From: Amber Willard <Amber.Willard@arun.gov.uk>
Sent: 03 February 2020 09:37
To: Planning.Responses <Planning.Responses@arun.gov.uk>
Subject: FW: AW/337/19/A

OBJECTION TO : AW/337/19/A . One Stop Store Application for signage on the Ship Inn site

PROPOSED SITE SIGNAGE

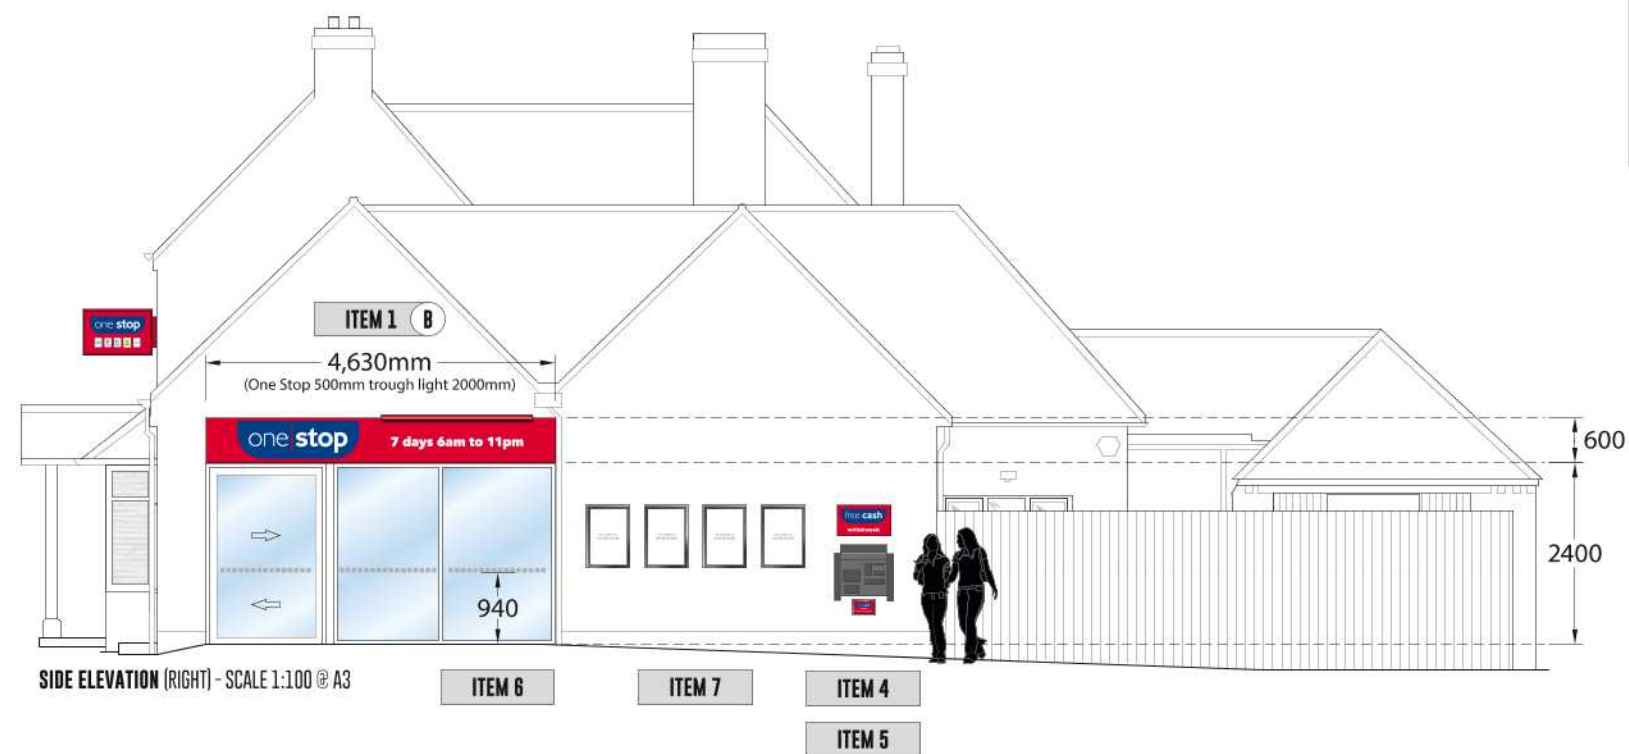
The proposed sign in the car park entrance is asking for trouble, it is an invitation to motorists to pull in quickly into the car park which would be highly likely to cause an accident of some description. Aldwick Street is a busy, narrow road so any unexpected manoeuvre is likely to be a safety hazard for tailing vehicles and those trying to exit the car park.

PROPOSED SITE SIGNAGE

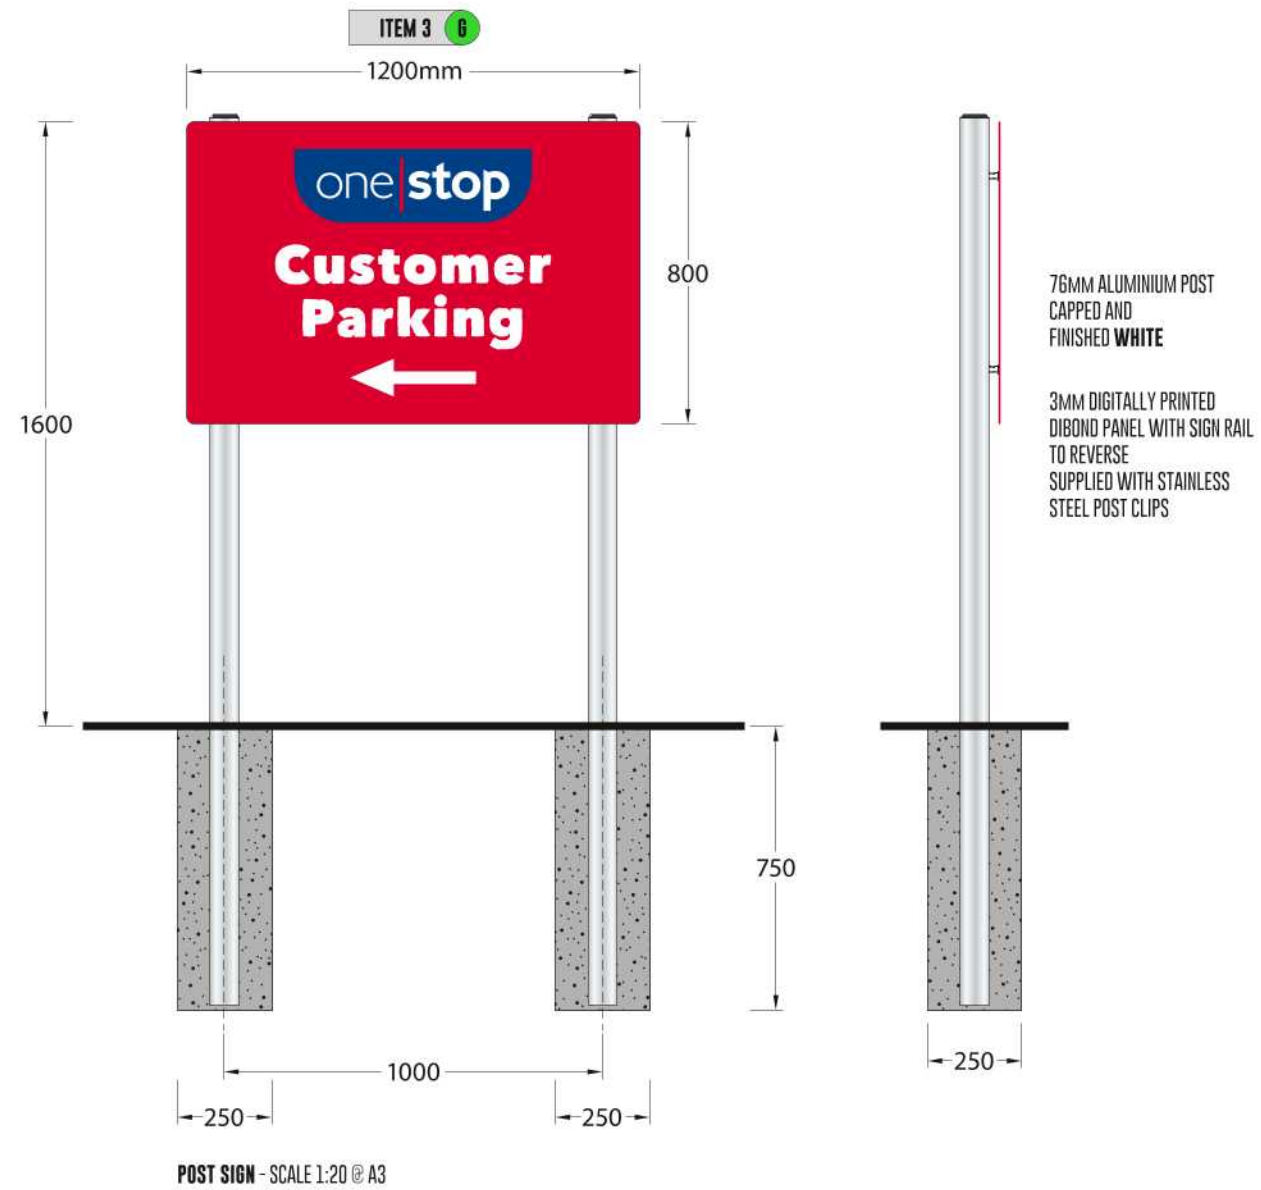
The proposed panels covering the bay windows disfigure the building and are out of character with the parade of shops on the other side of the road. There is also one extra panel proposed on the eastern end of the front elevation which would just add to the issue.
